Ribble Valley Borough Council
Housing & Development Control

Application no: **3/2020/1043**

Address: **Automotive Tools Hambledon View Read BB12 7PD**

Proposal: **Proposed alterations/first floor extension to create additional vehicle storage at ground floor level and office accommodation/storage at first floor level**

South Elevation

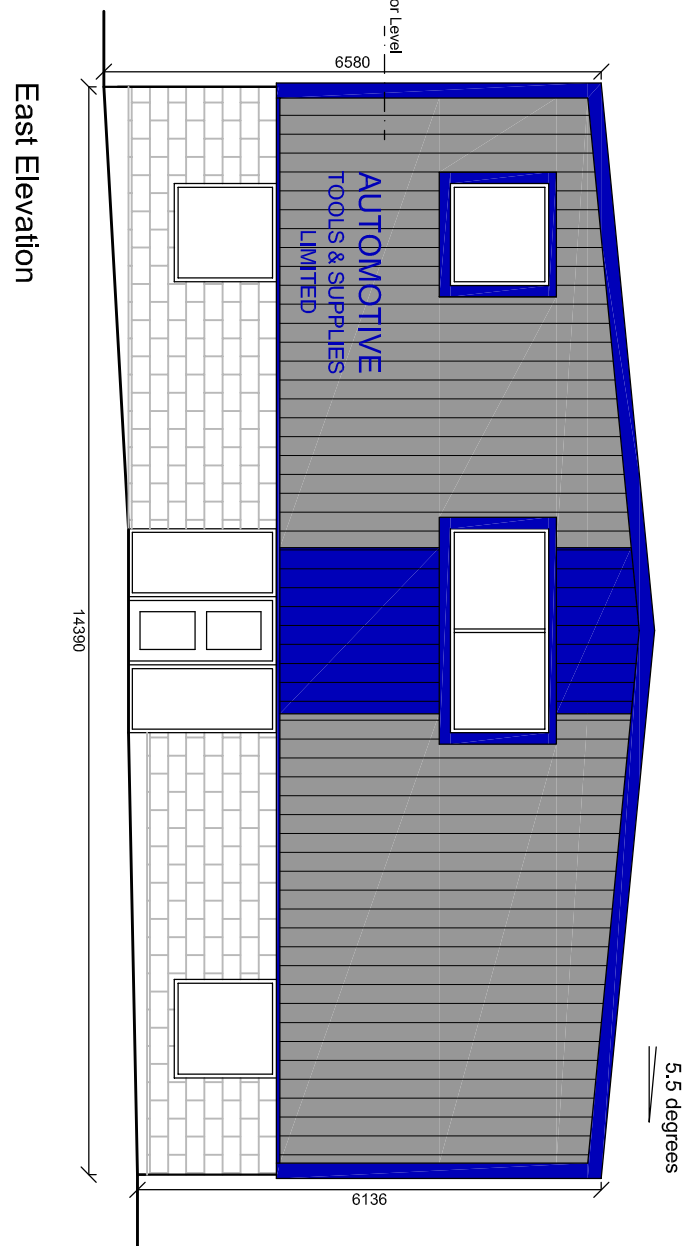
2. Before the building hereby permitted is brought into use, the garage doors shall be of roller shutter type as shown on the submitted plans and be permanently retained in that form thereafter for the lifetime of the development.
